### **CITY OF MERCER ISLAND, WASHINGTON**

Date 4/28/2021

#### **Subject: SUB20-0004, Short Plat**

Drawing file: SUB2 / sub20-004-tree plan2.pdf

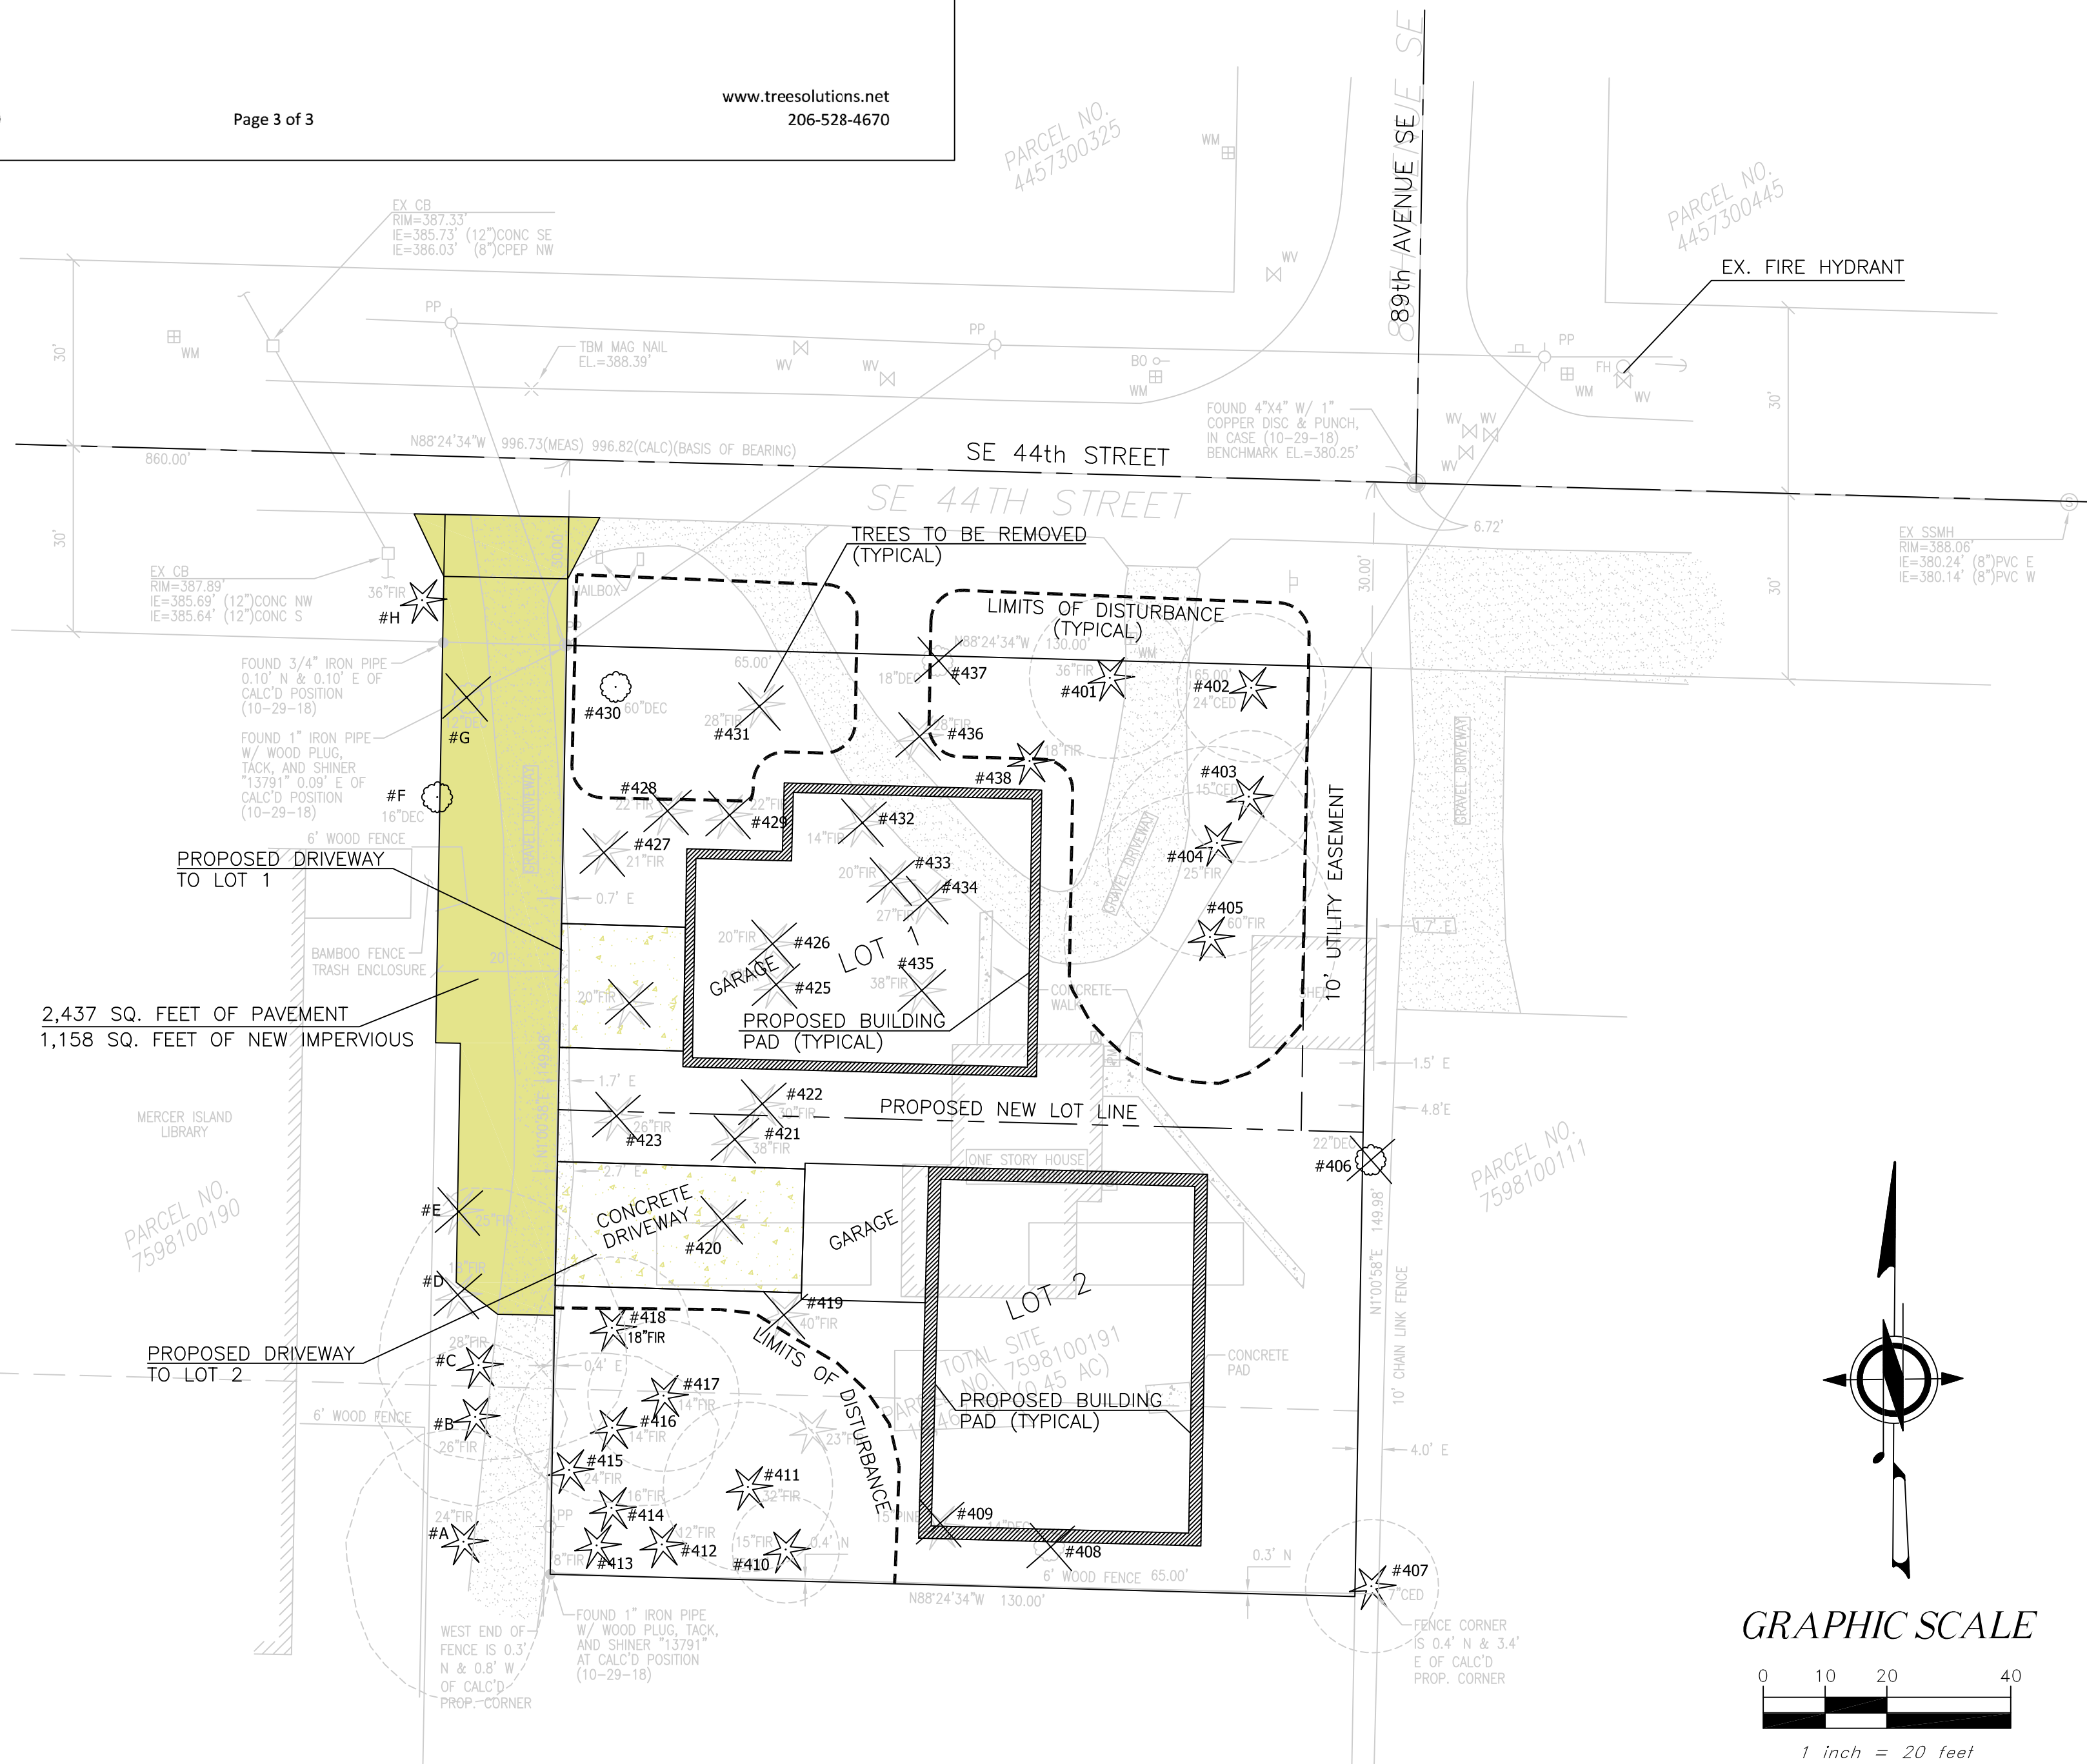
2. The tree protection plan will be submitted during building review. No further tree removal will be allowed unless it is justified under 19.10.060.A. Showing tree protection fencing at the Arborist stated tree protection zone (TPZ).

3. The tree protection fence shall be 6' chain-link fence secured into the ground. This will be called out on the Tree Plan during building review.
4. The Project Arborist is to be on site and in control of any excavation or grading within trees dripline. They will document and clean cut any root over 1" in diameter that needs to be removed. Call this out on Tree Plan during building review.

1. The plan showing numbered retained trees and building pad will be recorded as part of the plat. This plan should be the same or consistent with the Preliminary Tree Plan.
2. No tree identified for retention may be removed unless otherwise approved by the City arborist.
